Objection to Amended Planning Application: R/64/17/PL Location: St Mary's Close, Hurst Road, Rustington, BN16 3AP

Re: Objection to Amended Planning Application: R/64/17/PL

Location: St Mary's Close, Hurst Road, Rustington, BN16 3AP

We are responding to the amended plans for this development by MJH Homes. In our view this new proposal changes very little & most of our original comments in our letter dated 12th May remain valid.

Drg No: 151117_SS-01 Rev: D

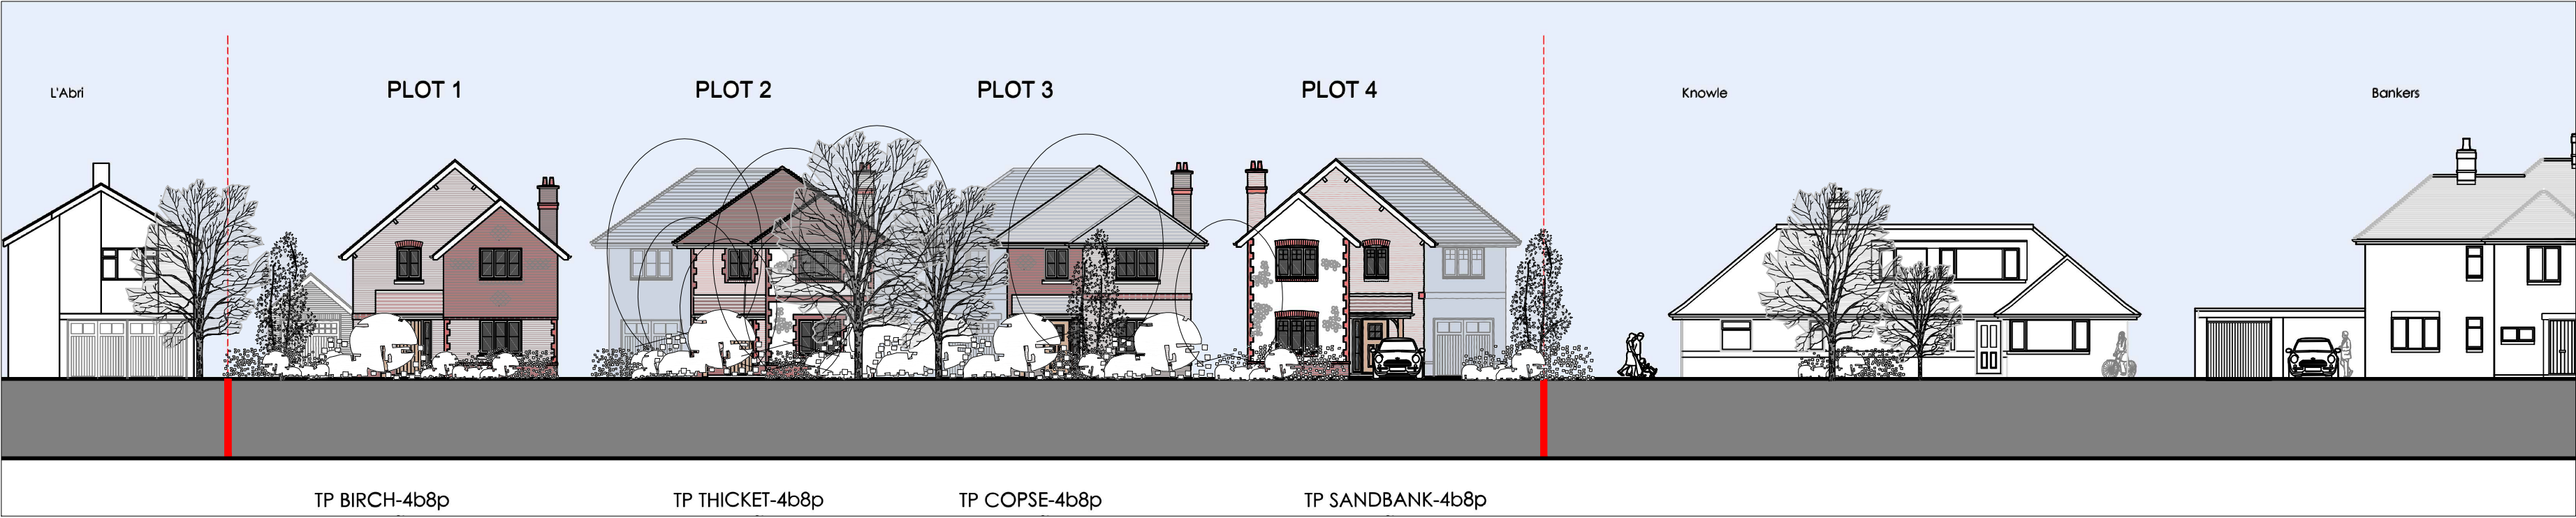
- 3) **Design & visual impact** -- The proposals are for two slightly different designs and the developer has attempted to make them look different by using various cladding materials. Further detail has been provided in the amendment, however our objection remains - that as seen from the elevation plans this is just superficial, they still look very similar (MJH Substitute Street Scene Drawing). They do not fit with the individual properties in Hurst Road and the proposed development will spoil its appearance and character. In fact the proposed scheme contravenes the Local Plan - D SP1 Design as it does *not* "*Respect, improve and enhance the existing surrounding environment*".
